ABP Reference No. ABP-315097-22

Fingal Ref FS5/ 057/22

Re: Whether the construction of a tennis court is or is not development or is or is not exempted development
Heather Cottage, Upper Cliff Road, Howth, County Dublin

PROPOSED
LOCATION

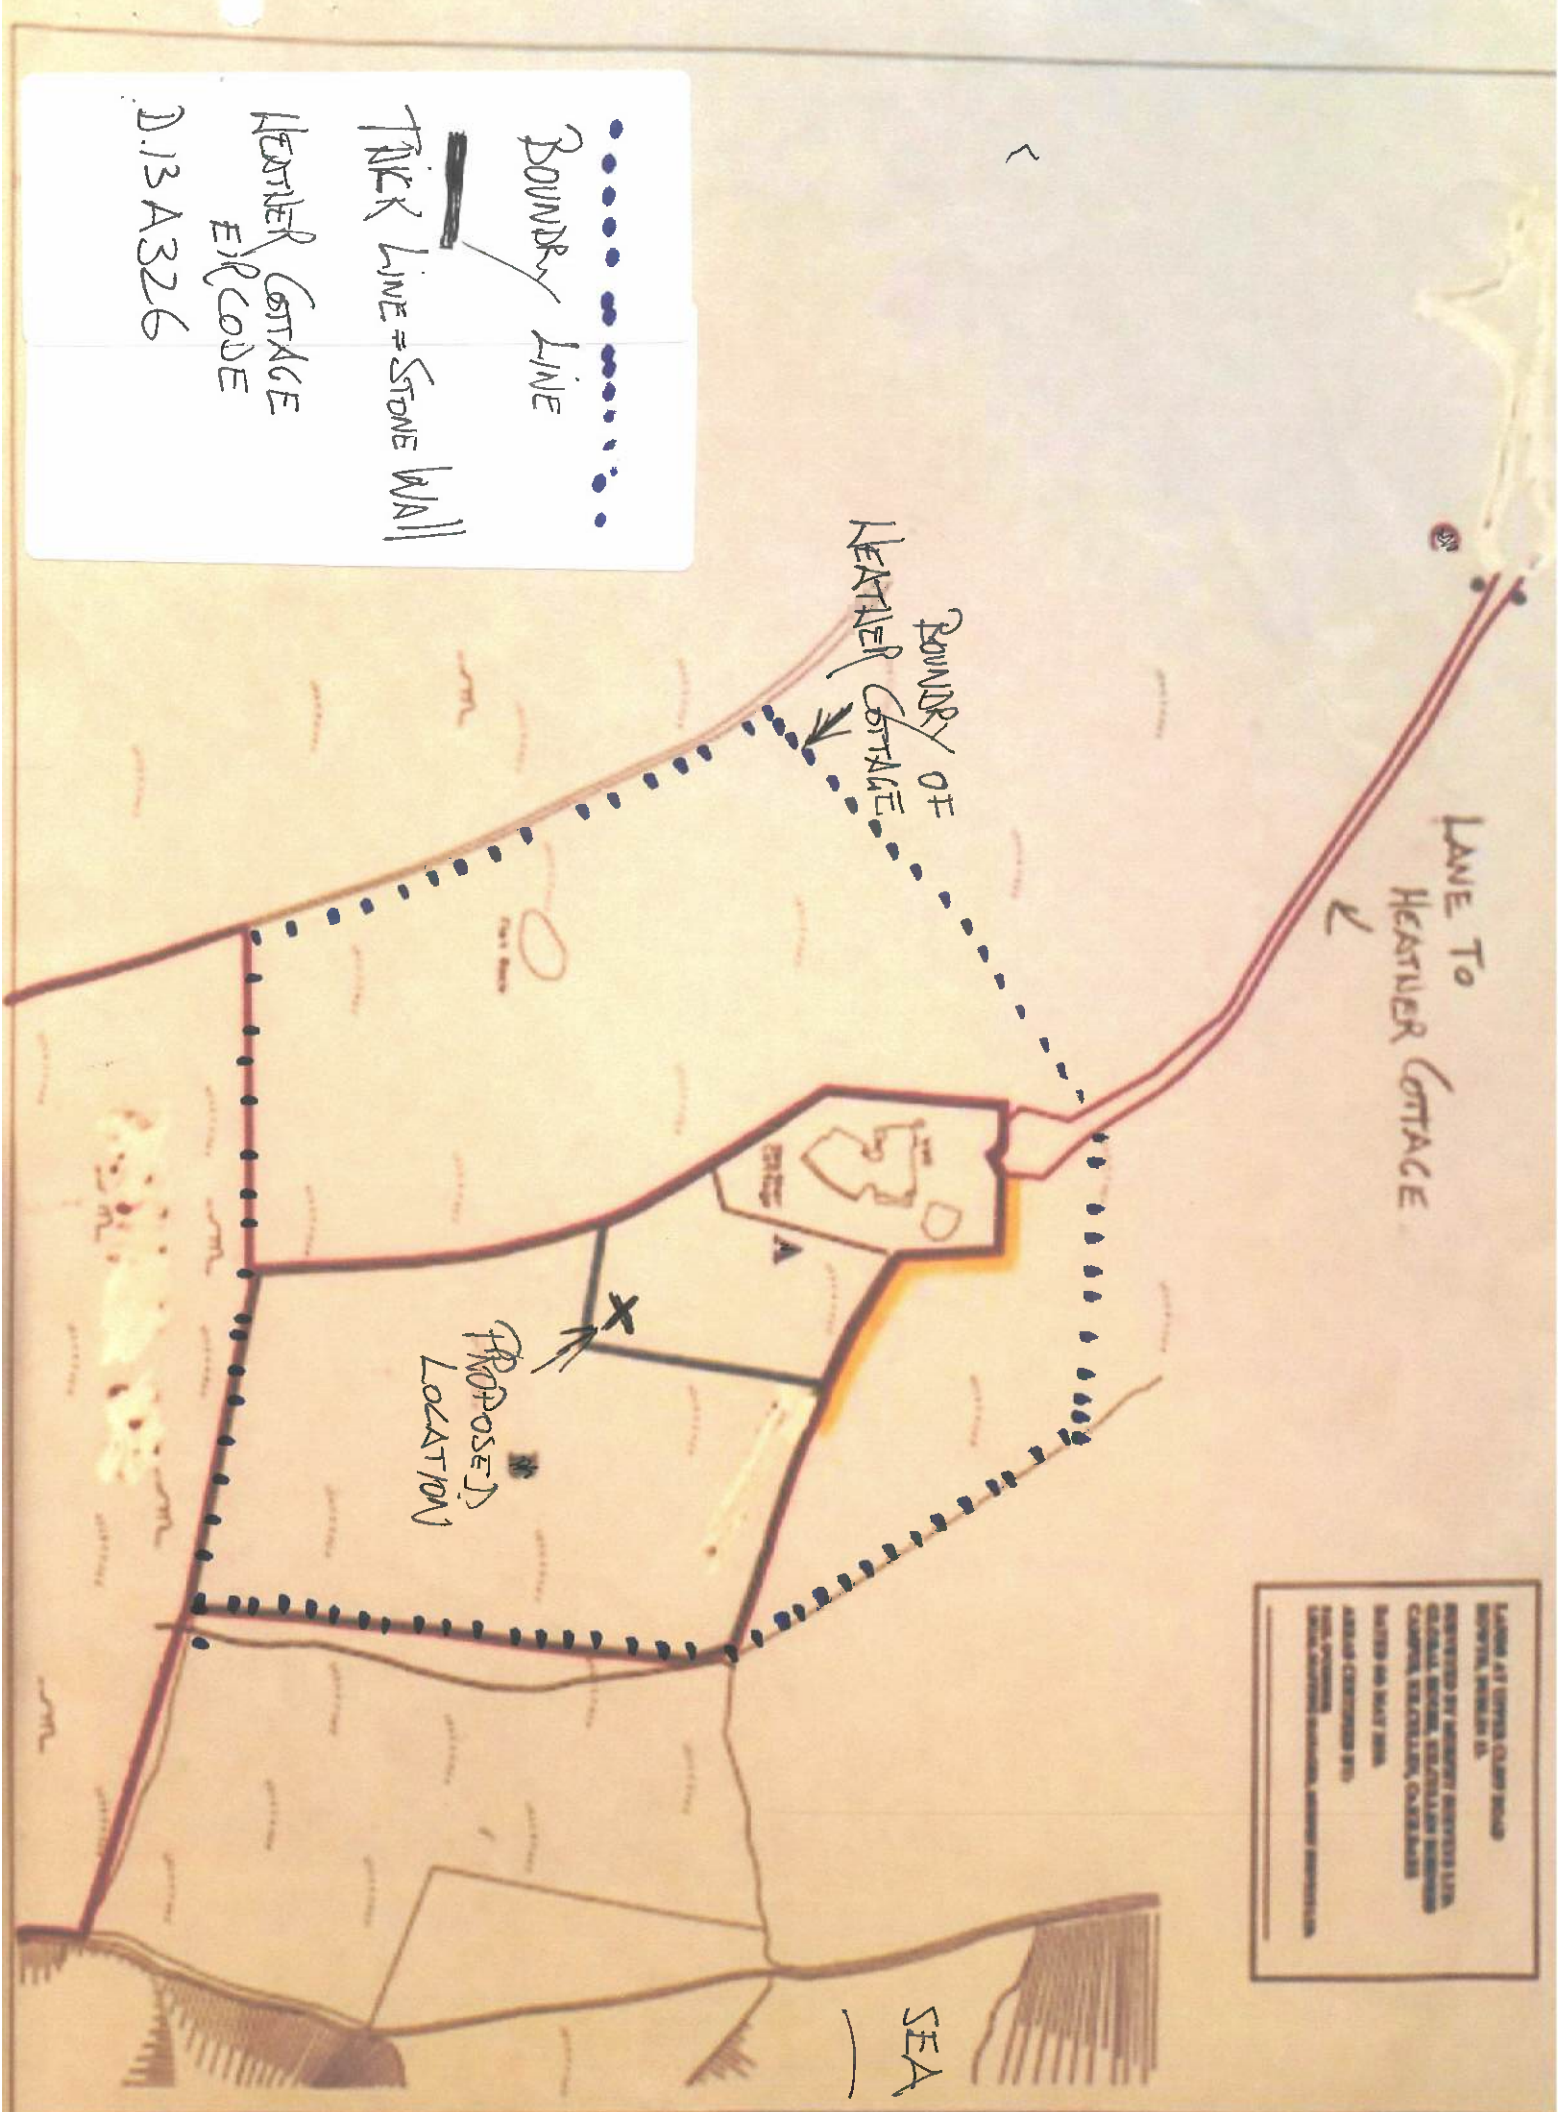
The submitted application is lacking in substantial detail. No drawings have been submitted with respect to the proposed development. The site slopes steeply and no cross sections have been given. This is of relevance as development within a residential curtilage that involves a change in level of 1m requires planning permission. It is not clear as to the extent of earth works that will be required to allow for a level tennis court.

In addition no details on proposed surfaces or ancillary details with respect to fences/boundary treatment for the tennis court have been given, although the applicant suggests that boundary treatment is not required for a pickleball court which is a development that was not suggested under the original section 5 application.

of substantial detail, cross sections etc. There is also a reference to fences / boundary treatment for the Tennis Court, proposed surfaces or ancillary details. As pointed out in my Appeal to the Board there will be no boundary treatments or fences associated with the Court as it will be used for Pickleball rather than Tennis and as a consequence no fences or boundary treatments are required. I propose to use the standard Tennis Court hard surface and there will be no question of the ground level within the curtilage of the dwelling being altered by one metre or more. The ground level will not be altered at all .
